RESPONSE TO REQUEST FOR INFORMATION: INTERCONTINENTAL HOTEL ALTERATIONS AND ADDITIONS MODIFICATION 2 (SSD 7693 MOD 2)

This letter has been prepared by Urbis on behalf of Mulpha and relates to the above State Significant Development Application (**SSDA**) modification at the Intercontinental Hotel (115-119 Macquarie Street, Sydney) and Transport House (99-113 Macquarie Street, Sydney).

DESIGN CONCEPT

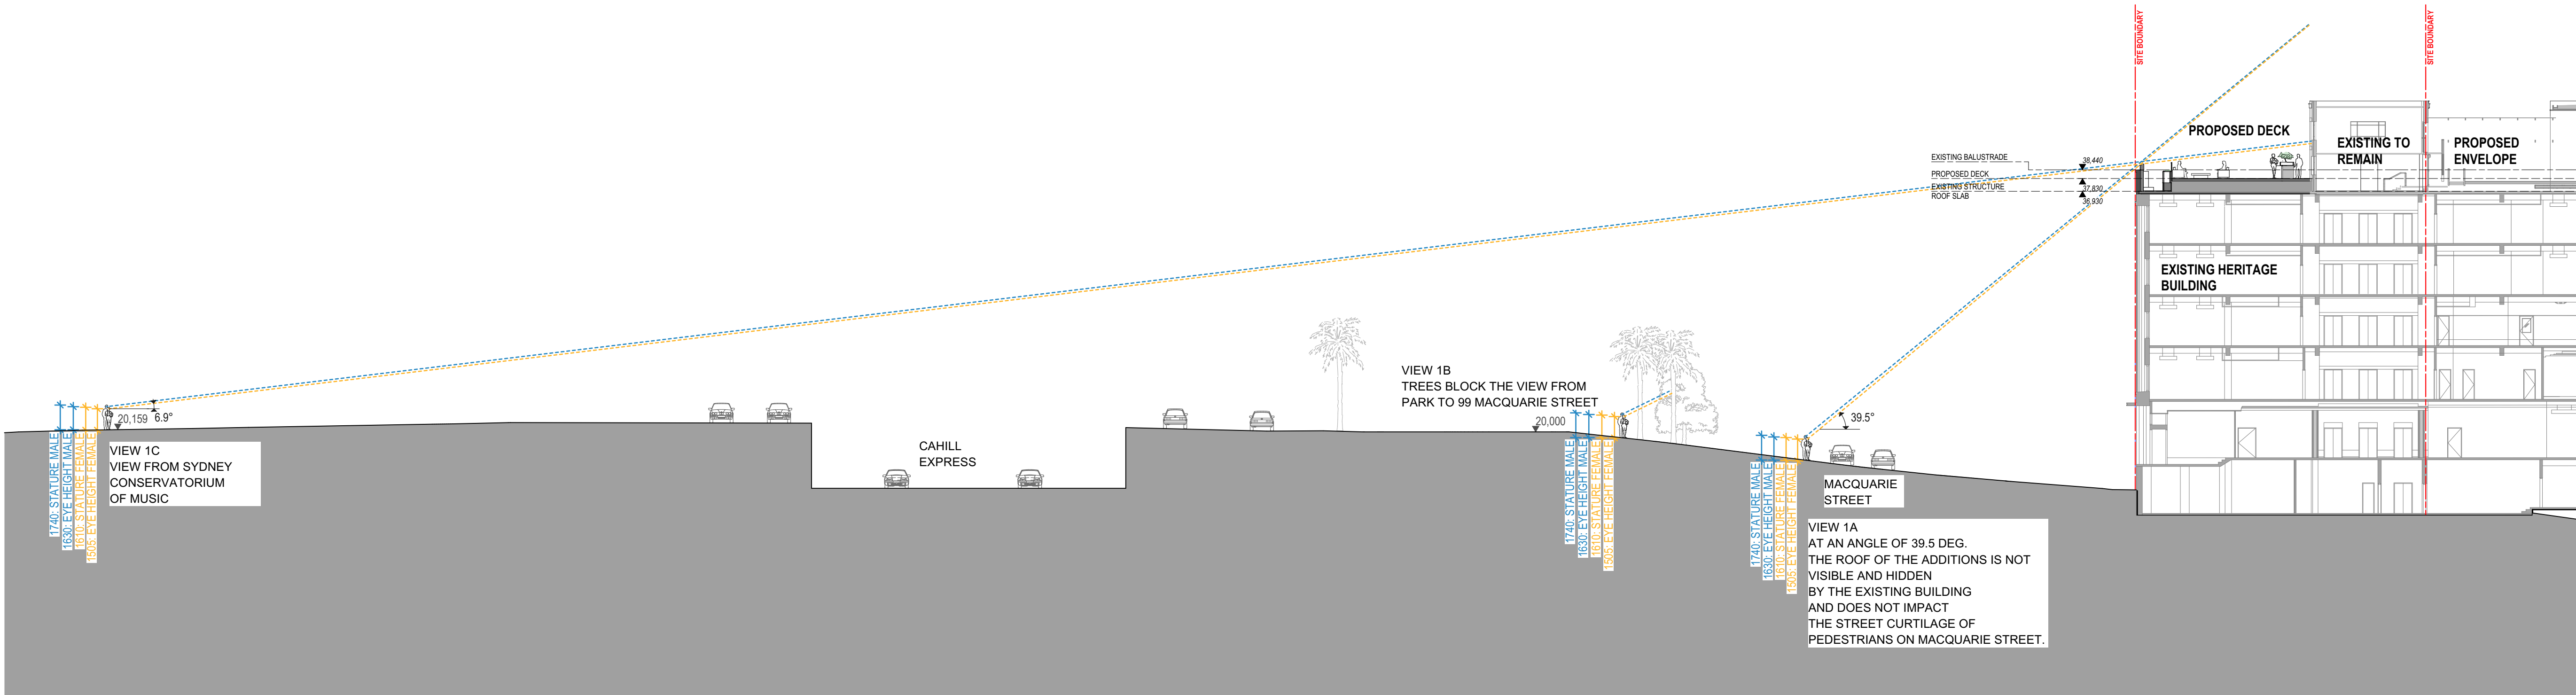
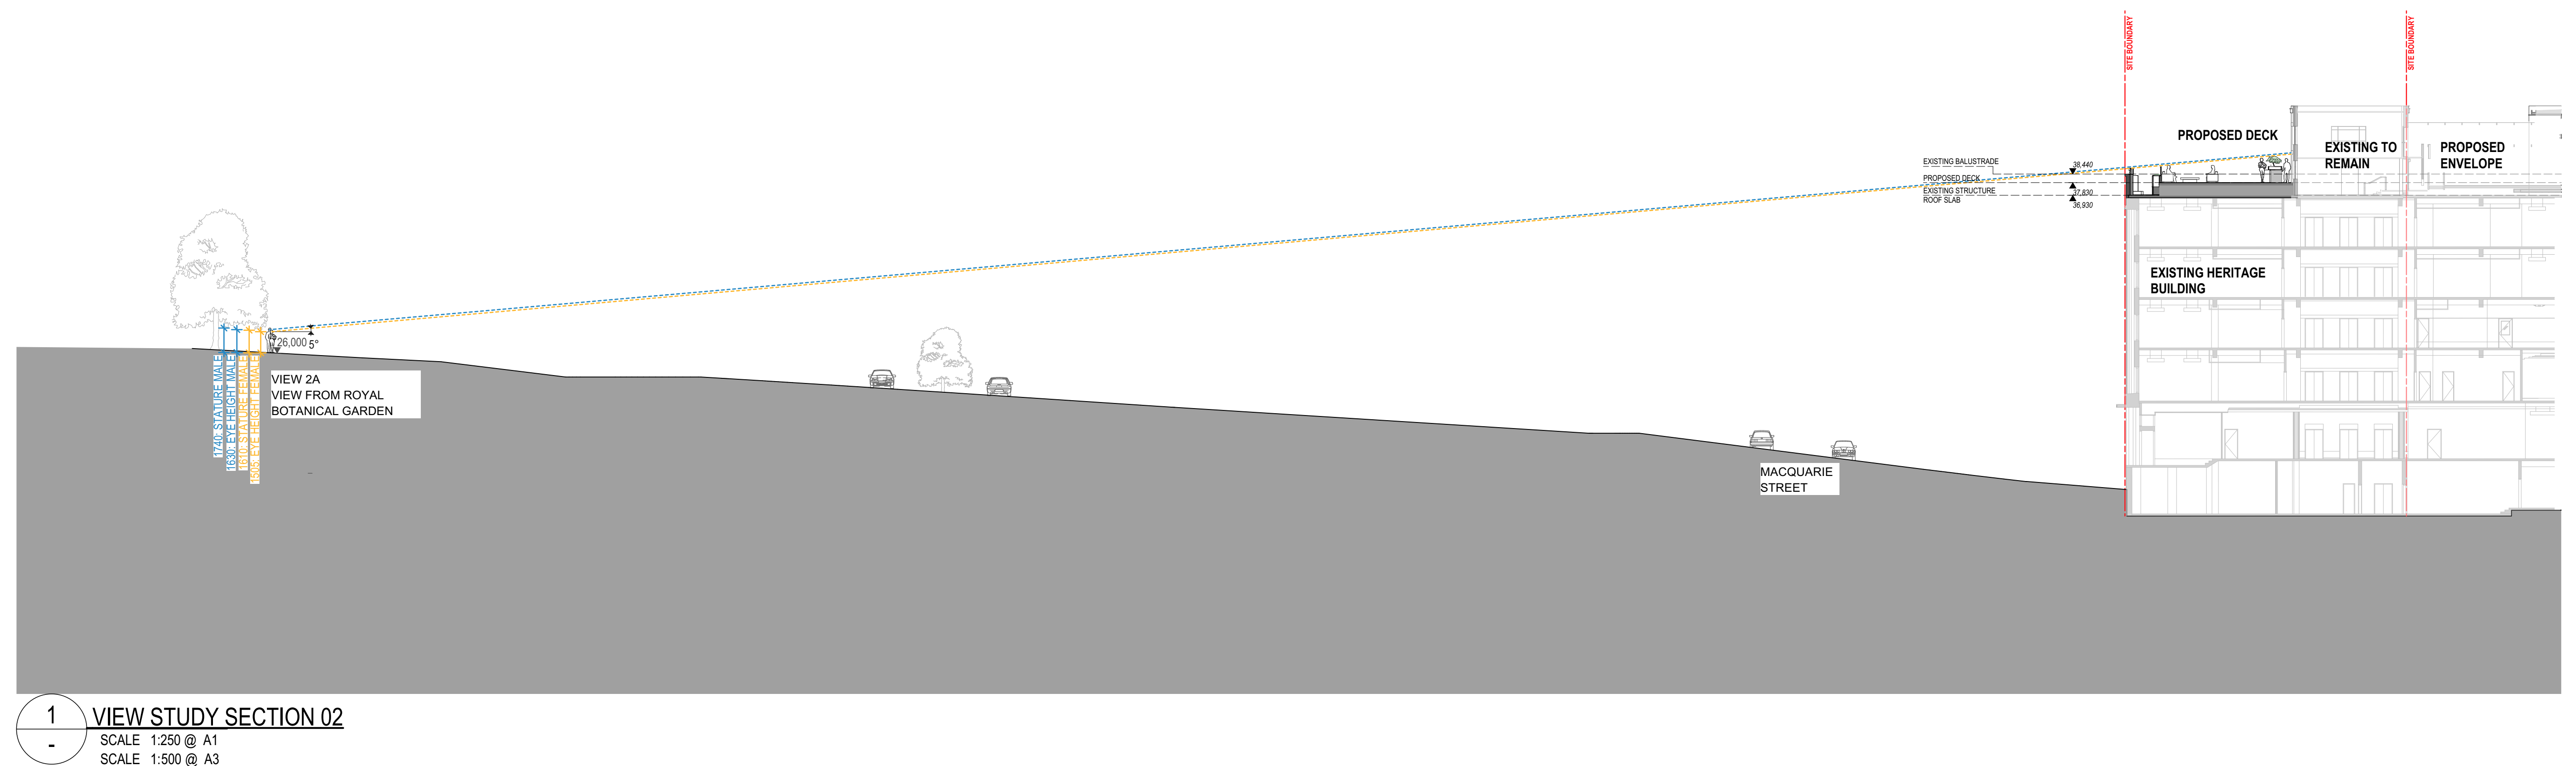
Issue	Response
<p>Provide preliminary details into the external terrace/ bar area. The Department agrees with Heritage NSW comment and requires further details into fixed structures that may be located on the external terrace.</p>	<p>Cottee Parker have outlined the design concept for the external bar area within the Design Package appended to this correspondence, noting that it will be refined in the subsequent 'detailed' SSDA.</p> <p>The design will include high-quality, low and relaxed outdoor furniture, set on top of a hardwood deck that is flanked by low scale planters.</p> <p>Section drawings are included from key public domain vantage points (Macquarie Street, Sydney Conservatorium of Music, Royal Botanic Gardens – near and far). The sections illustrate that the proposed raised deck and balustrade arrangement would be sufficiently setback from the existing parapet to be unsighted from these vantage points. The sections also demonstrate that any fixed furniture and/or bar would similarly be unsighted.</p> <p>These details will be further explored and developed as part of the next stage of the project.</p>

<p>The Department does not accept the external terrace/ bar area would not include structures (including bar, awnings/shade structures etc) and that no details are available. While future SSDAs would consider the detailed design, preliminary concept details are required to consider the potential visual impacts of the proposal.</p>	<p>As above.</p>

1 VIEW STUDY SECTION 01
SCALE 1:250 @ A1
SCALE 1:500 @ A3

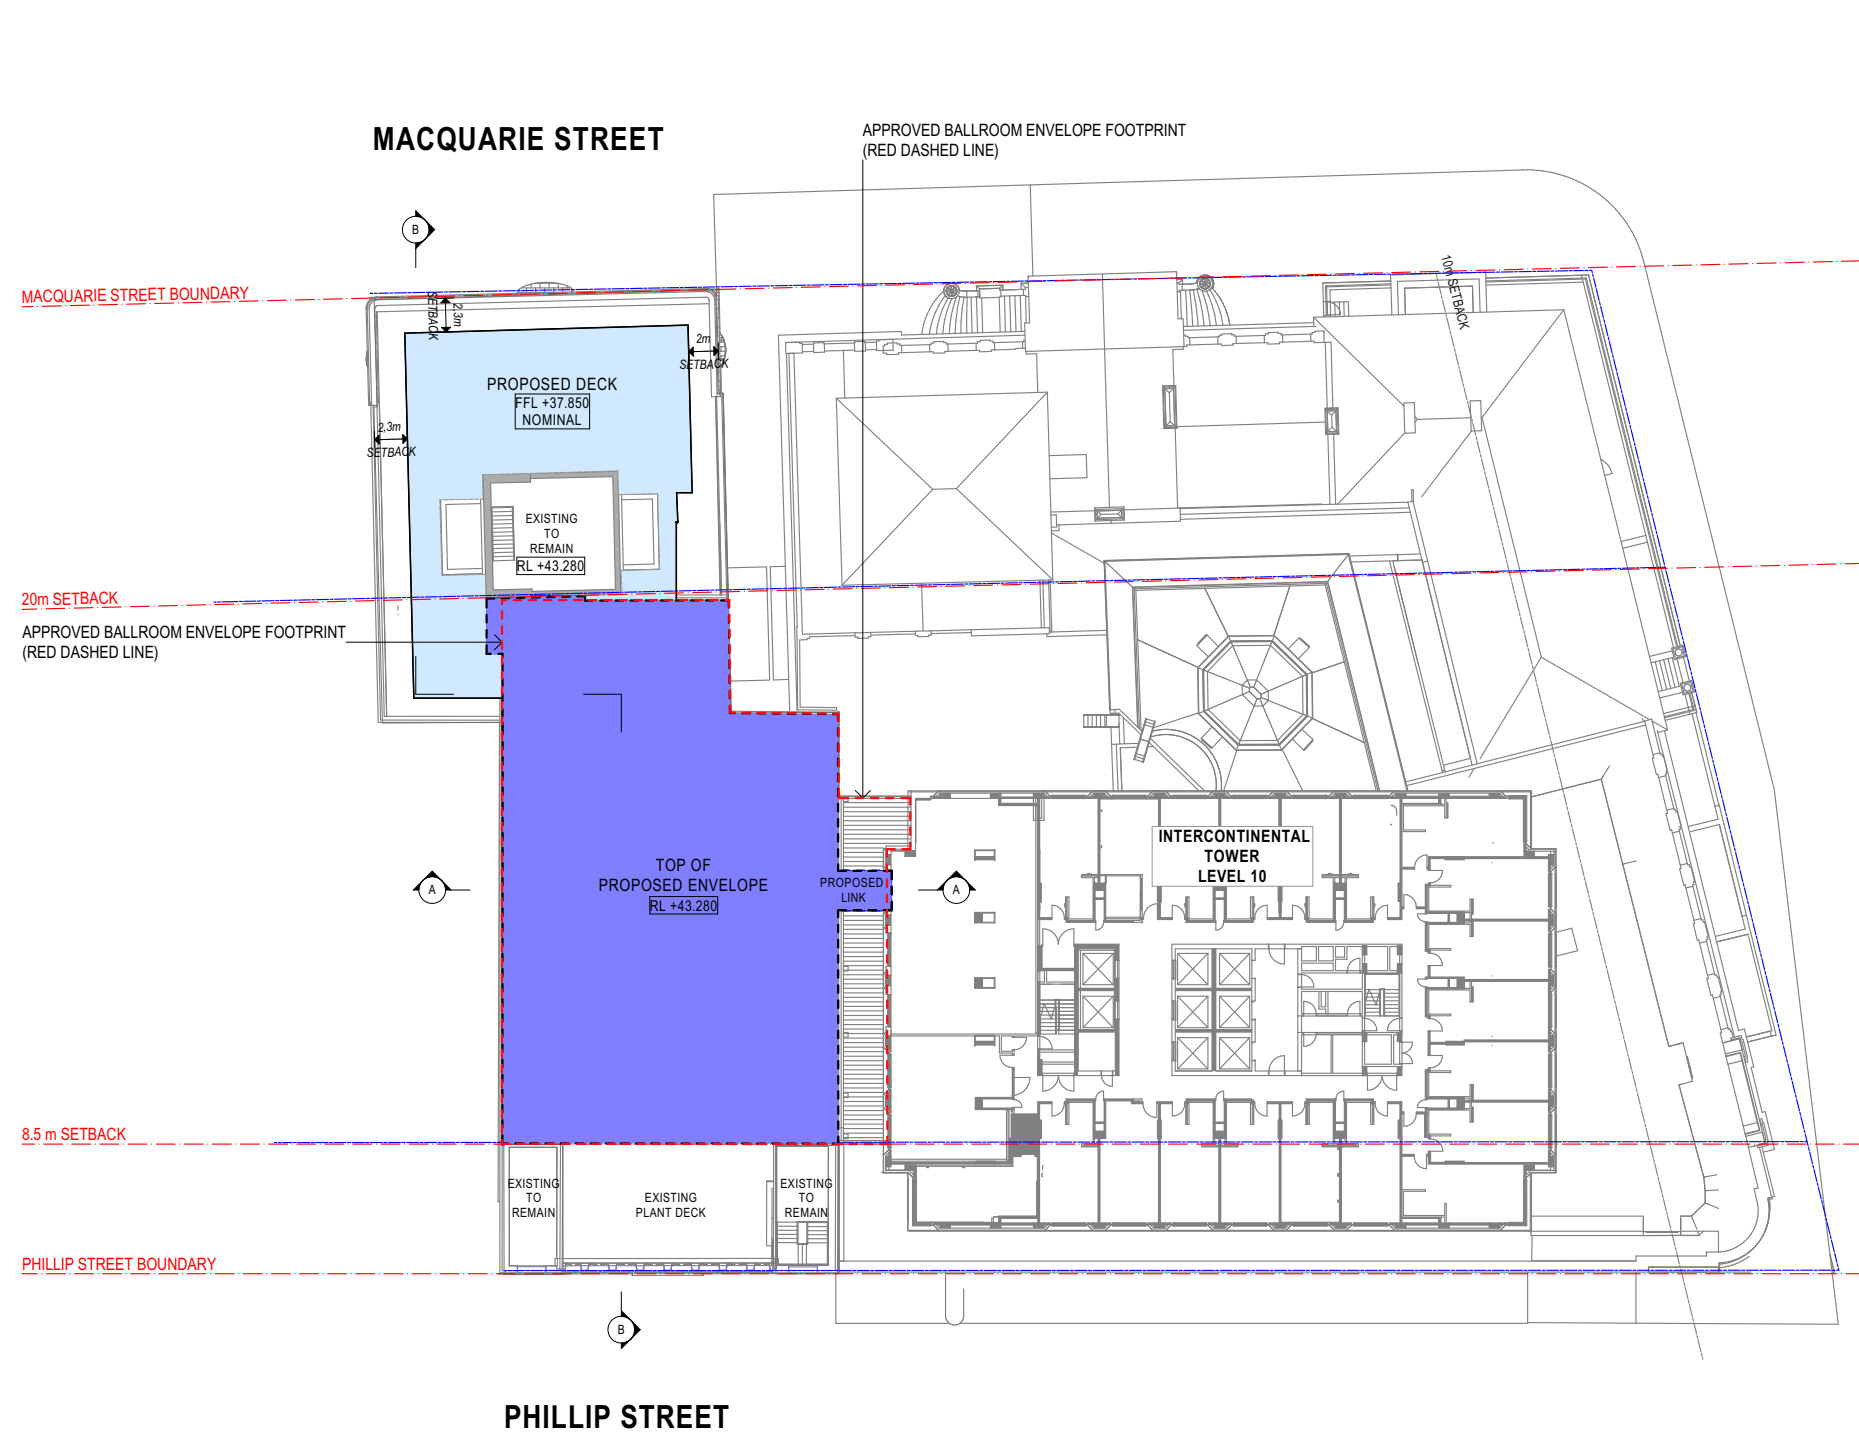
<p>Previous comments highlighting the overall impact of any rooftop additions within the 30m setback in this highly sensitive location are reiterated. Although there is a reduction to the previously approved envelope, the modified proposal features new deck addition to the roof (along with balustrade and elements associated with a roof top hospitality venue that are likely to follow), which would have an adverse heritage impact.</p>	<p>It is recognised that there are elements within the 30m setback to Macquarie Street that were not envisaged by (or approved in) the original consent. However, Urbis does not agree that these amendments will have a major adverse impact on the setting and significant views around the Treasury Building.</p> <p>The proposed deck itself will not be visible behind the parapet so there is no potential for impacts on the setting or views. The existing</p>

Issue	Response
	<p>parapet would remain dominant in the streetscape.</p> <p>A detailed design package with updated heritage and visual impact analysis will be provided at detailed SSDA stage – which will demonstrate the acceptability of the project.</p> <p>As above, Cottee Parker have provided preliminary analysis (appended to this letter), which demonstrates the proposed deck structure is unlikely to be visible from key public domain vantage points.</p>
